M60/M62/M66 Simister Island Interchange

TR010064

7.21 APPLICANT'S RESPONSES TO EXAMINING AUTHORITY'S FIRST WRITTEN QUESTIONS

Version	Date	Status of Version
P01	5 November 2024	Deadline 3

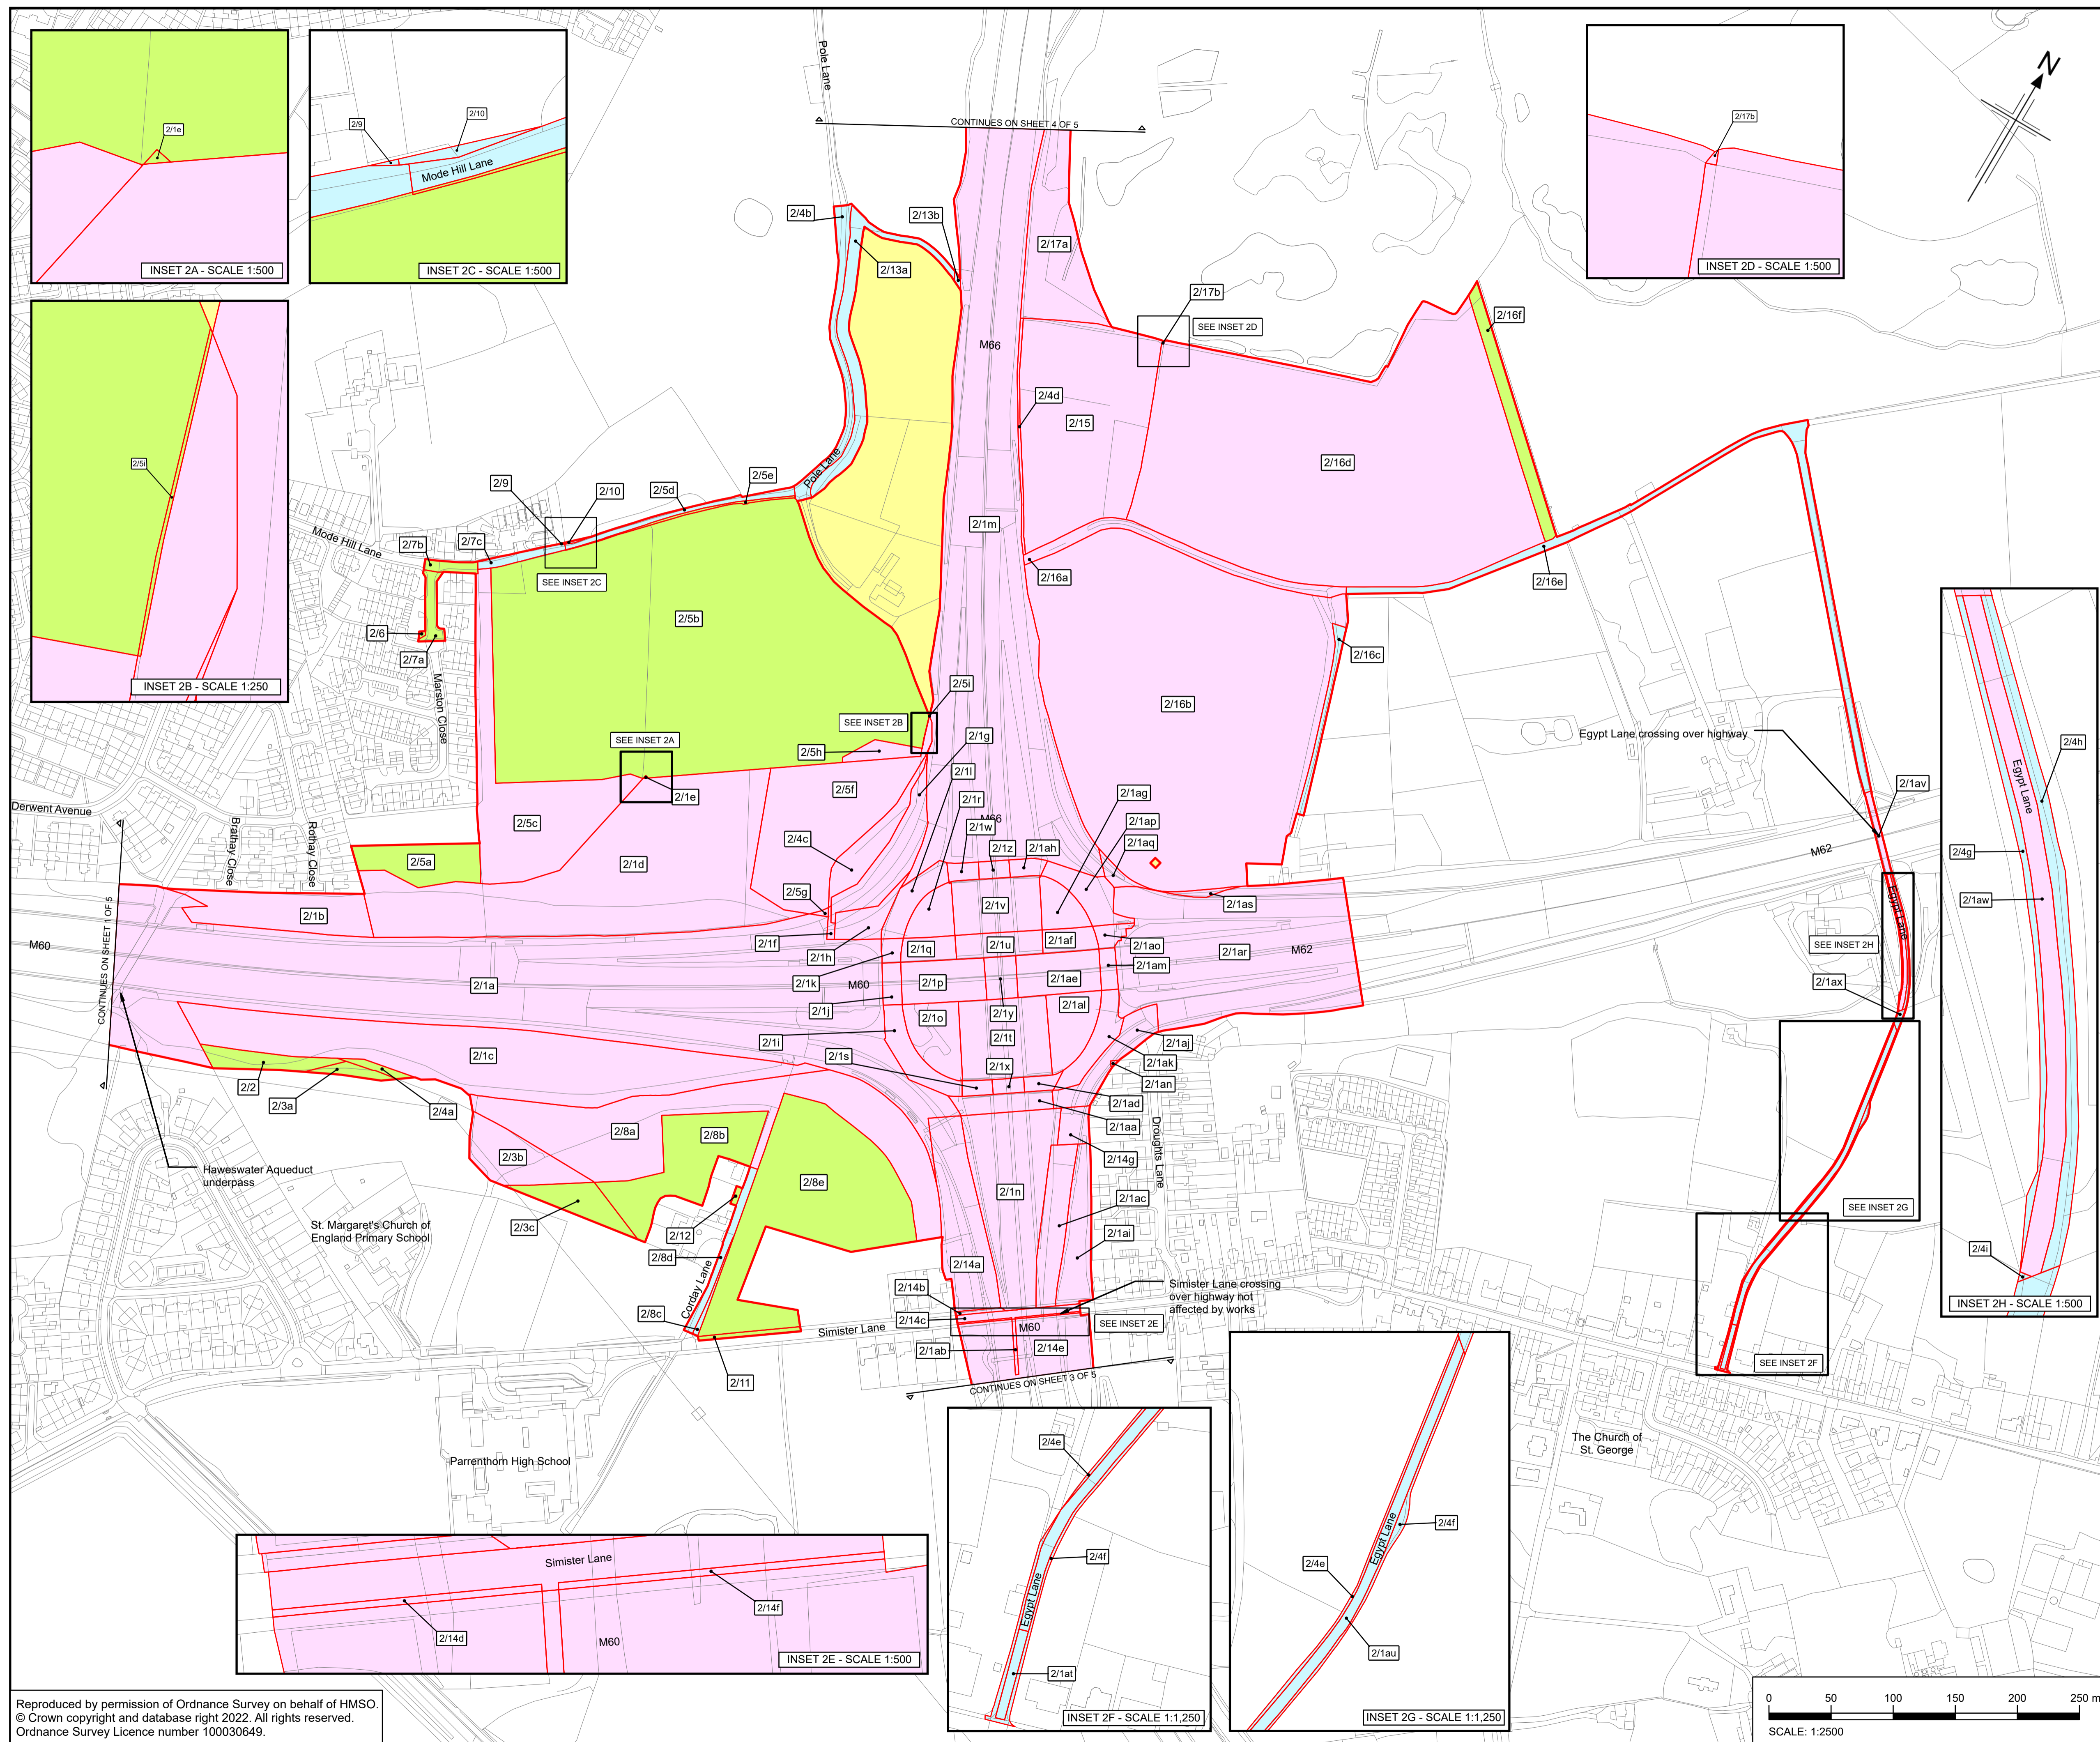
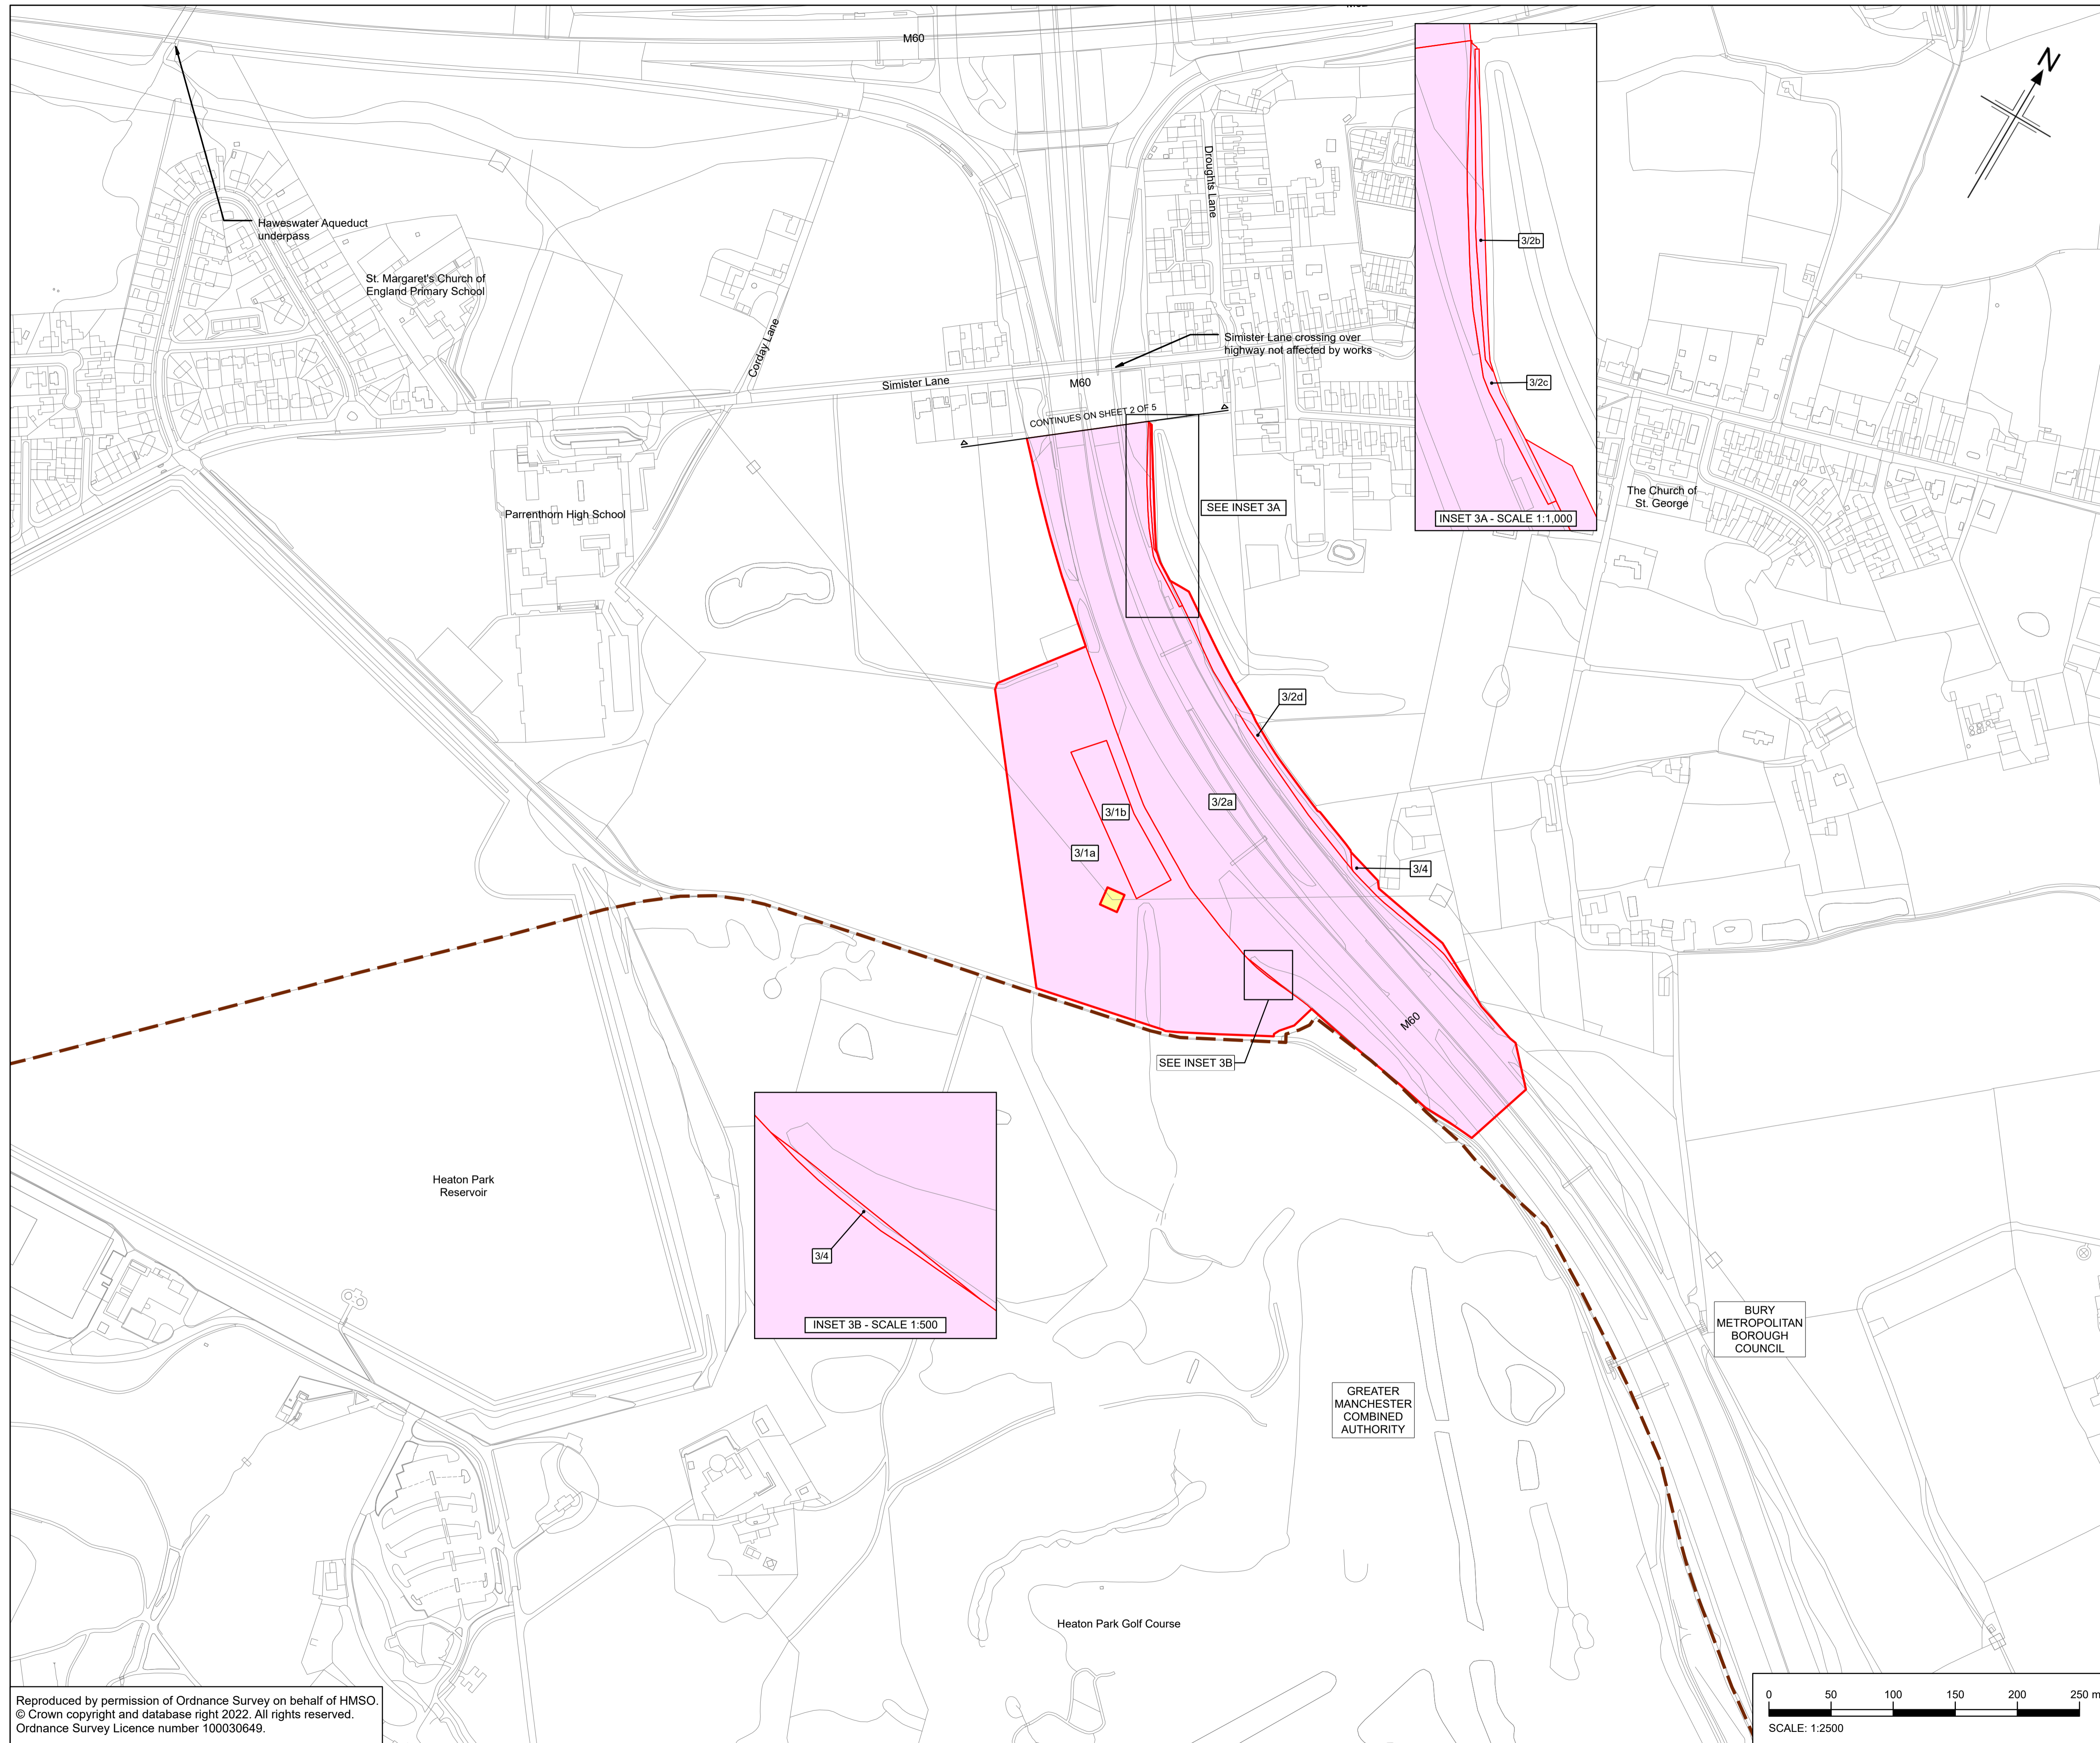
Written Question Number	Question to: -	Reference (in bold) & Question	Applicant's Response
		There is no plot 3/3 but there are two plots marked 3/4 on the Land Plans [AS-005]. Please correct.	
CA.1.5	Applicant	Clarification Clarify why you are requesting permanent land Rights over Egypt Lane (including the verges) (plots 2/1at, 2/4e, 2/4f, 2/1au, 2/4i, 2/4g, 2/4h, 2/1ax, 2/16e).	The Applicant confirms that permanent rights are required on Egypt Lane to facilitate off-network access for future maintenance of the permanent infrastructure provided as part of the Scheme, including but not limited to, the new drainage attenuation pond and swale, eastern abutment of Pike Fold viaduct, northern abutment of Pike Fold Bridge and the external earthworks and landscape planting on the new "northern loop".
CA.1.6	Applicant	Clarification Clarify why you are requesting permanent land Rights over Pole Lane and land adjacent to it (plots 2/4b, 2/13a and 2/13b).	The Applicant confirms that permanent rights at Plot 2/13a and 2/13b as shown on the Land Plans [AS-005] is required to maintain new trees, shrubs and hedgerow planting to be located on the eastern side of Pole Lane. Provision of these hedgerows has been agreed with the landowner and are shown on sheet 2 of 5 of Figure 2.3: Environmental Masterplan, of the Environmental Statement Figures [APP-057] and these new hedgerows are to be provided to facilitate visual screening. Rights are required over plot 2/4b to facilitate maintenance access to plots 2/13a and 2/13b.

CA.1.4	Applicant	<p>Land Plans</p>	<p>The Applicant has submitted revised Land Plans [AS-005] at Deadline 3 of the Examination to correct the error. Plot 3/3 is now correctly labelled in Inset 3B.</p>
